20<sup>th</sup> February, 2024.

**WRITTEN REPRESENTATIONS ON BEHALF OF ALAN DAVID  
LEWHELLIN GRIFFITHS AND JANICE ELIZABETH GRIFFITHS OF  
MERRION FARM, BINES GREEN, PARTRIDGE GREEN, HORSHAM, RH13  
8EH**

Attached at appendix 1 is a copy of sheet 27 of the Onshore Works Plans (APP-009), showing the extent of our clients' property edged pink, and on which it is clear that the DCO route of the construction corridor passes right across the farm and will occupy a substantial portion of it.

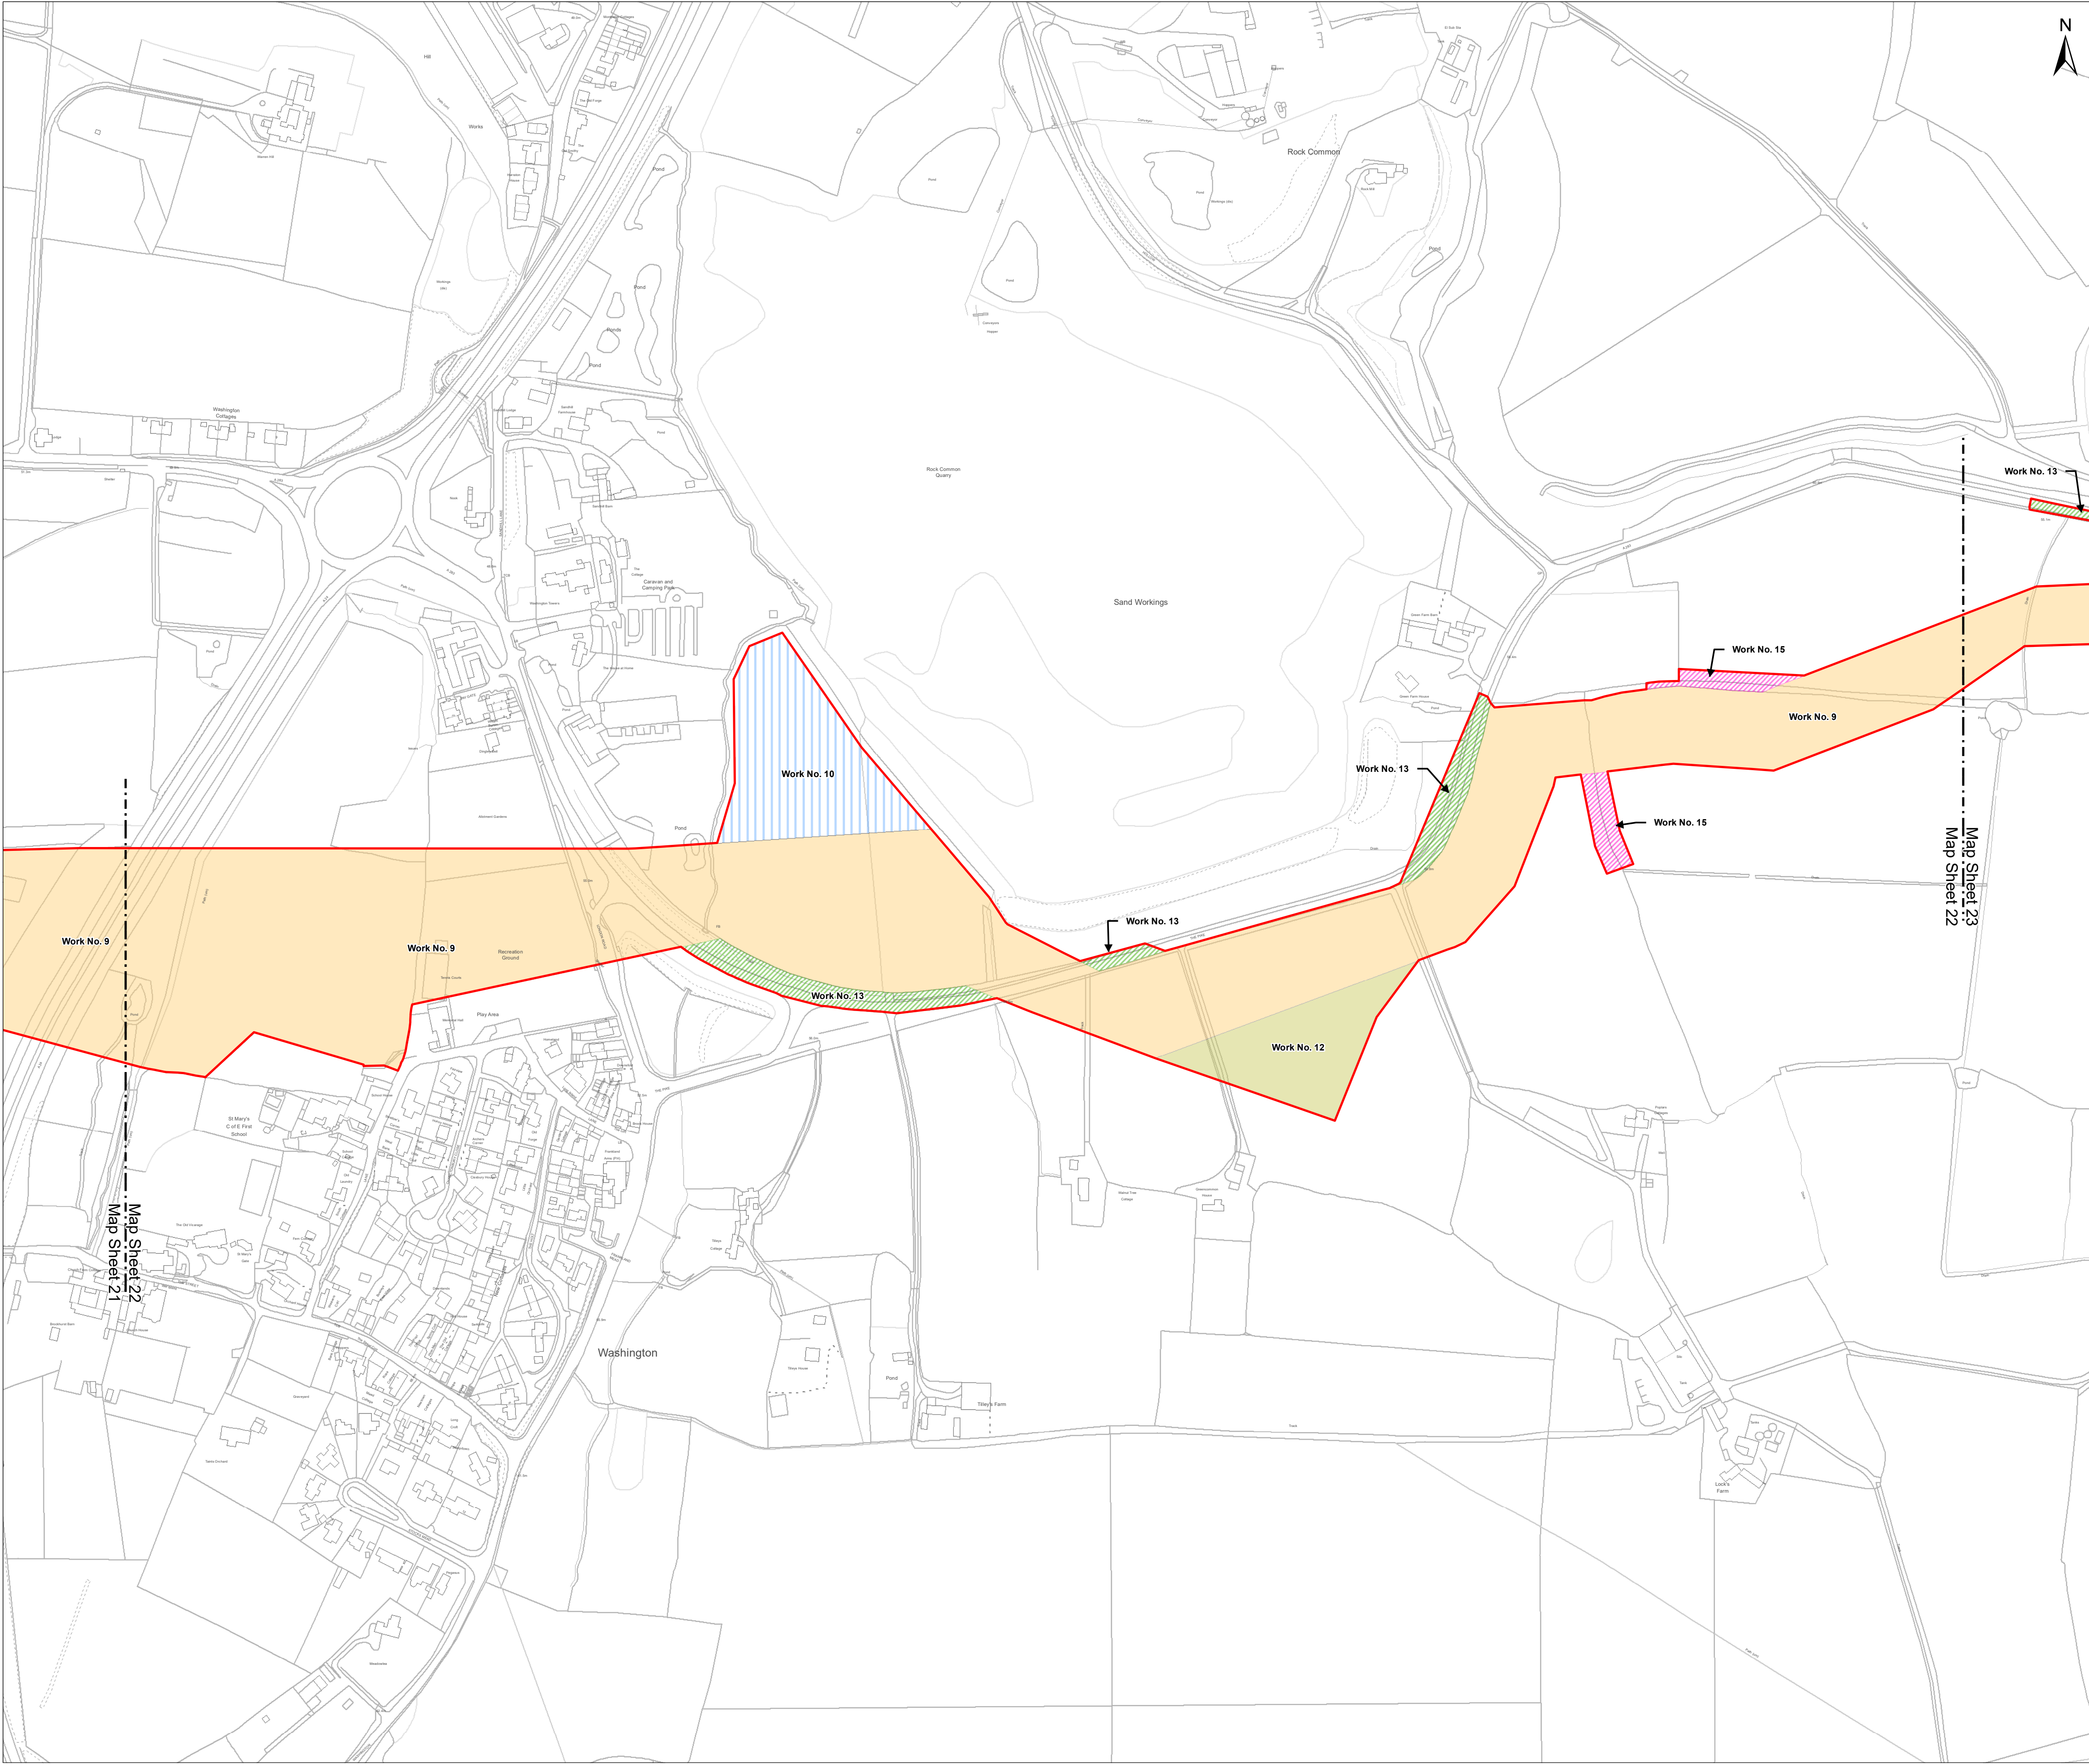
Because of this, it is imperative that RWE takes reasonable steps to minimise these impacts, and we submit that they have not done this. The Secretary of State has to be satisfied that the DCO area is no more than is reasonably required. We have marked on the plan approximate widths of the DCO corridor in places (measured by scaling), and on these dimensions we make 2 points:-

- i) We understand that RWE will only require a 40 m wide strip for construction in most places, within which will be a 20 m wide permanent easement strip for the cables. Thus there is no justification for the DCO corridor being so wide, given the potential impacts thereof referred to above. A narrower corridor, particularly if routed more sensitively, could significantly reduce the disturbance on the 3 tourism enterprises referred to above..
- ii) RWE has advised that they will be making a trenchless crossing under the River Adur at the north end of the farm. However, they have given no justification for why this will require such a large corridor width in this area. Its impacts on our clients will be excessive at this width given the amount of land take.

#### **4. Construction access along farm drive and associated compound areas (marked blue on plan)**

It will be noted that this access passes close to the Griffiths' residence and the holiday let, whilst the 2 compound areas will take up significant space and render the parking for the Shepherd's hut unusable.

alternative option was proposed, namely a direct access off the public road avoiding the farm drive. The Griffiths have not received any explanation as to why this option, which would have caused far less disturbance to them, has not been included in the DCO application. We believe the option of using the farm drive for this access is unreasonable given:-

1. That other options are available
2. The level of disruption it will cause to:-
  - i) Their day to day living in the house
  - ii) Their farming operations, due to conflicts of use on the farm drive
  - iii) The loss of business from the holiday let, shepherd's hut and campsite. On this point, it is interesting to note the effect on these during recent construction of a slurry lagoon on the farm, which involved the importation of a lot of soil for which heavy lorries used the farm drive for a period of 13 months from February 2022 to March 2023, such use possibly being similar to the heavy traffic which construction for the Rampion project will involve, albeit that is likely to be over a period of 3 years or more. The following table, using the Griffiths' own figures from that experience, demonstrates the effect:-
